Our Ref: R/2020/17/A
File No: 2022/059877
Your Ref: SSD-12618001

Request for Advice – 104-116 Regent Street, Redfern – Student Accommodation (SSD-12618001)

Notwithstanding the above, the **City has reviewed the accompanying documentation and objects to the proposal** in its current form based on the following matters:

DRAWING NO.
DA7.03

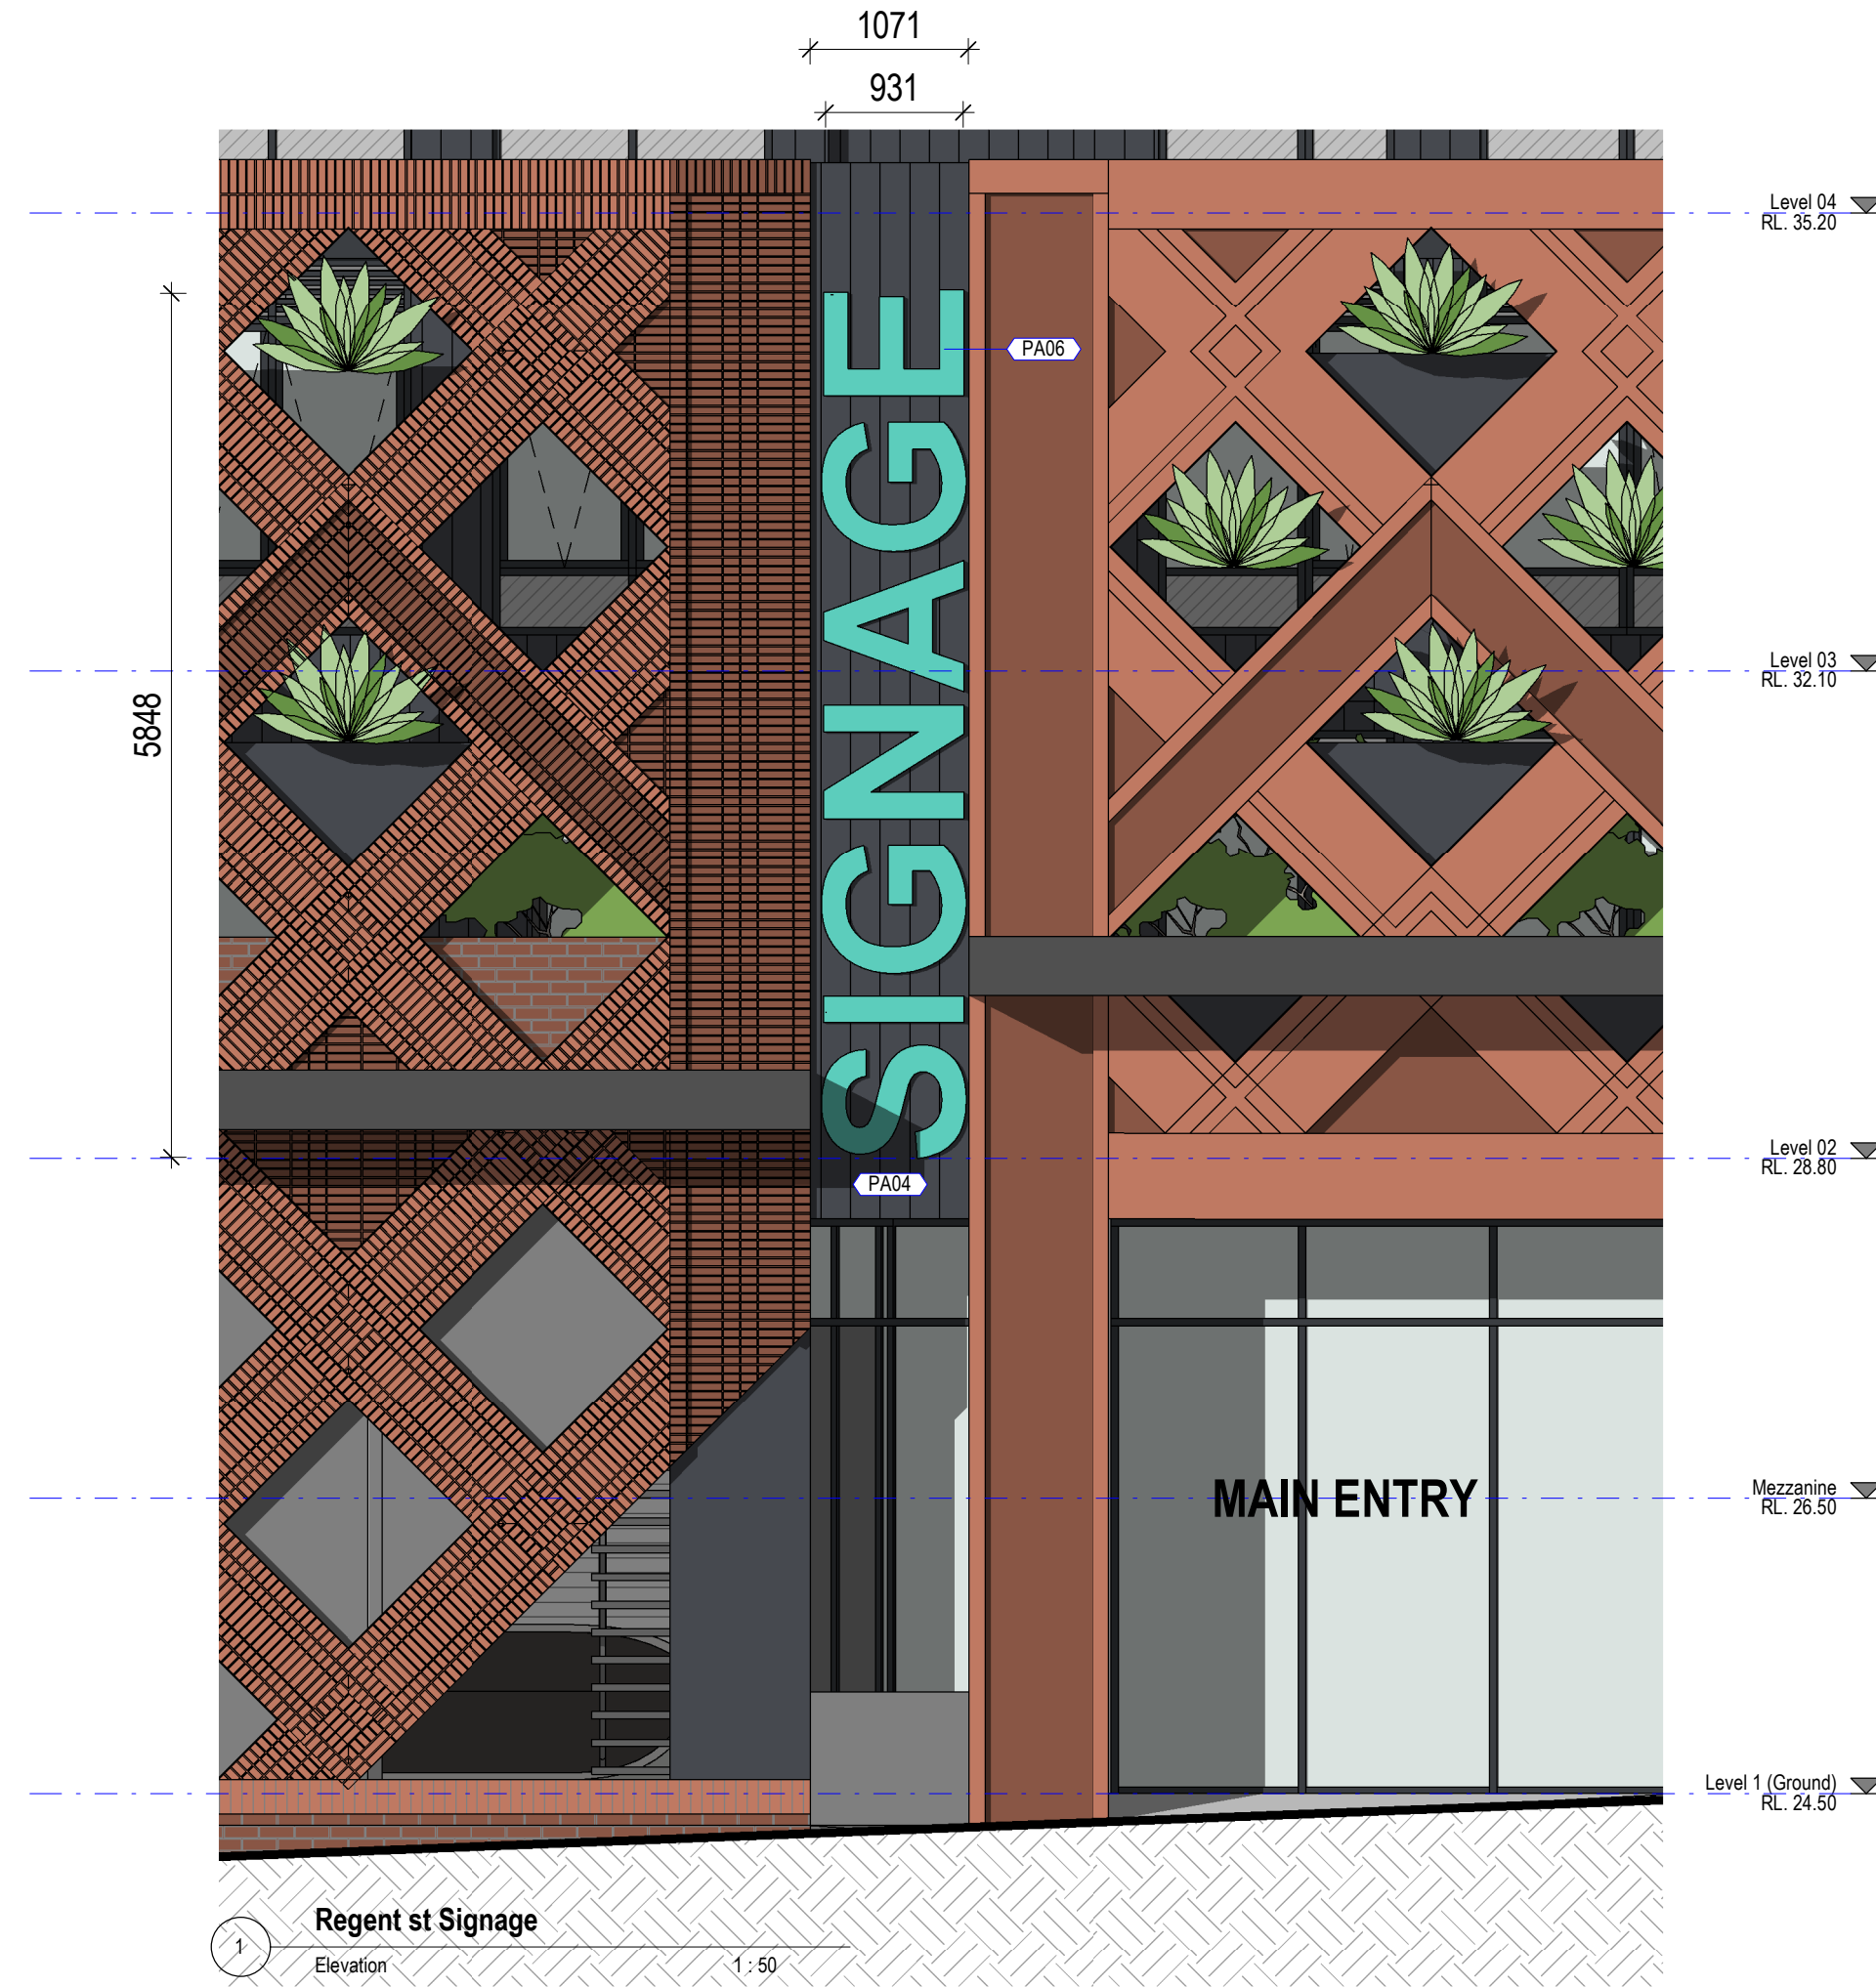
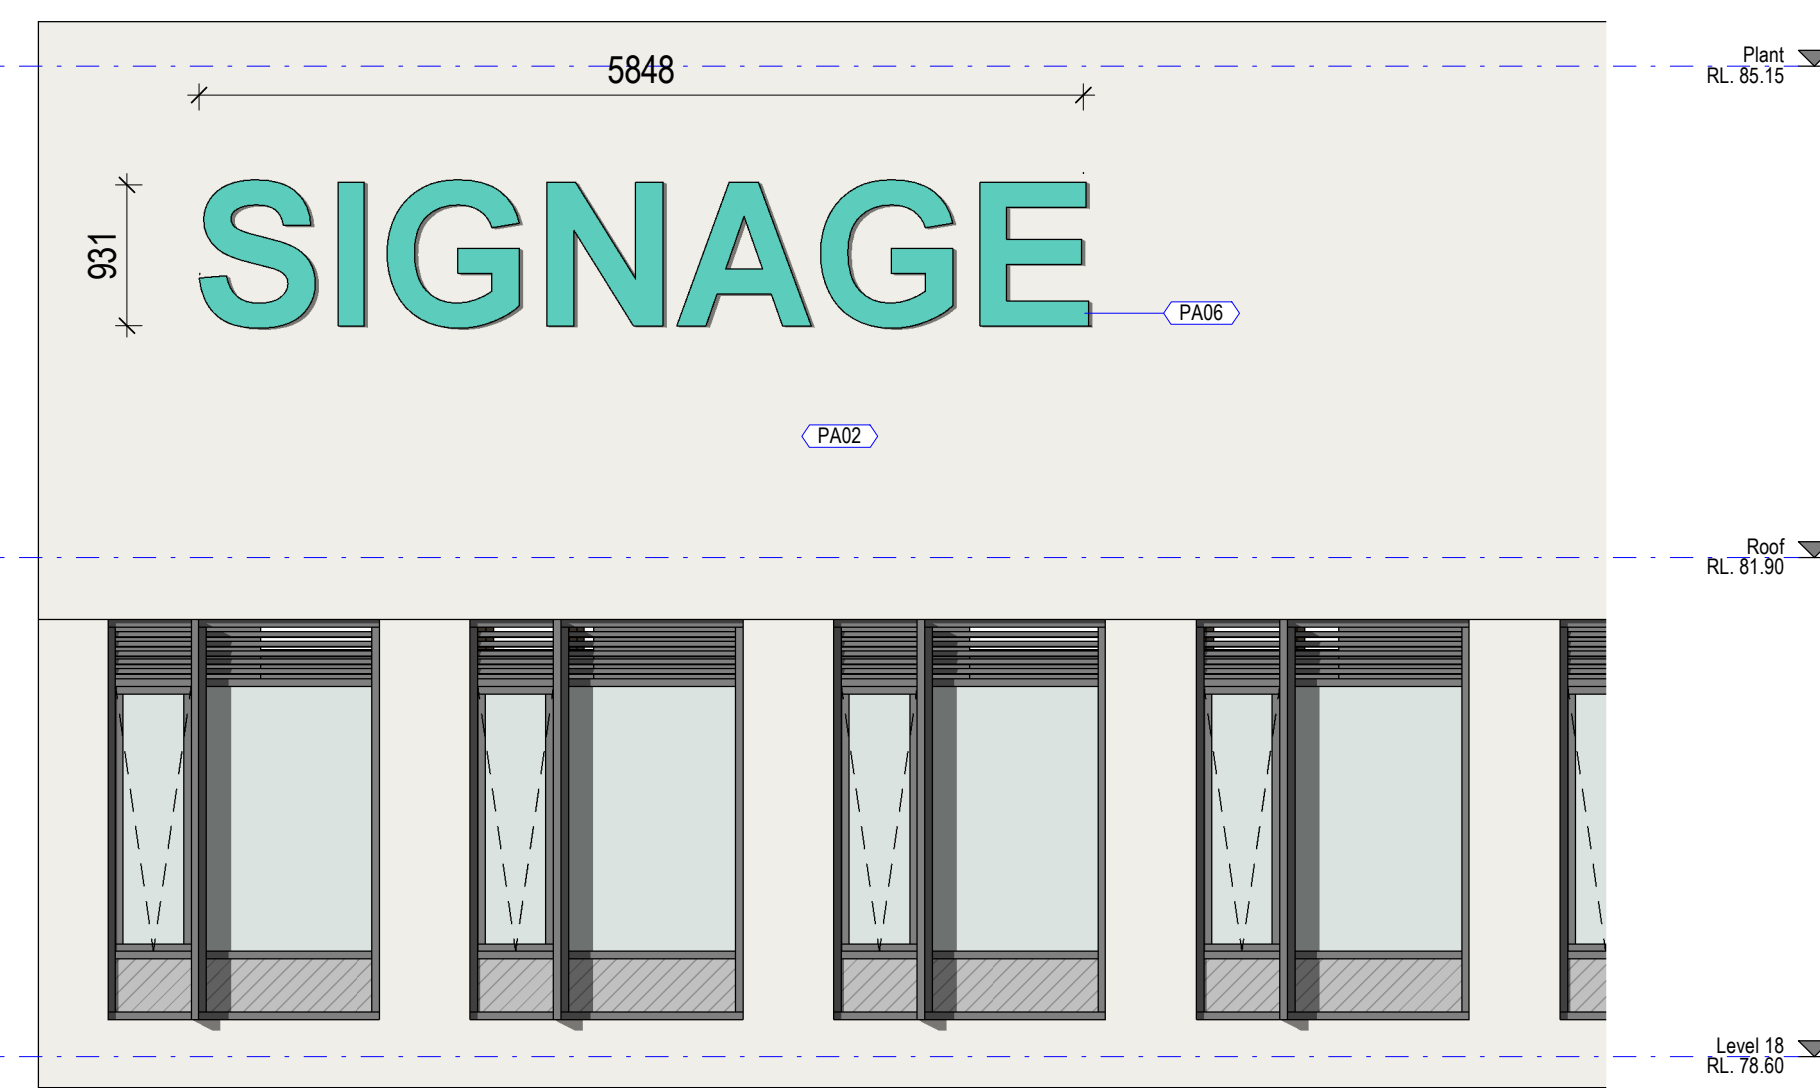
The Regent Street podium signage is not supported as it is not in accordance with RCUDP 3.4.2 signage requirements. An under-awning sign would be supported which assists identifying the entry to pedestrians.

Two top of building signs are proposed which contribute to visual clutter. The William Lane signage is recommended to be removed as this will be partially blocked by the Gibbons Street towers. The colour of the proposed signage is not supported as it highly contrasts and is not sympathetic with the proposed colour palette.
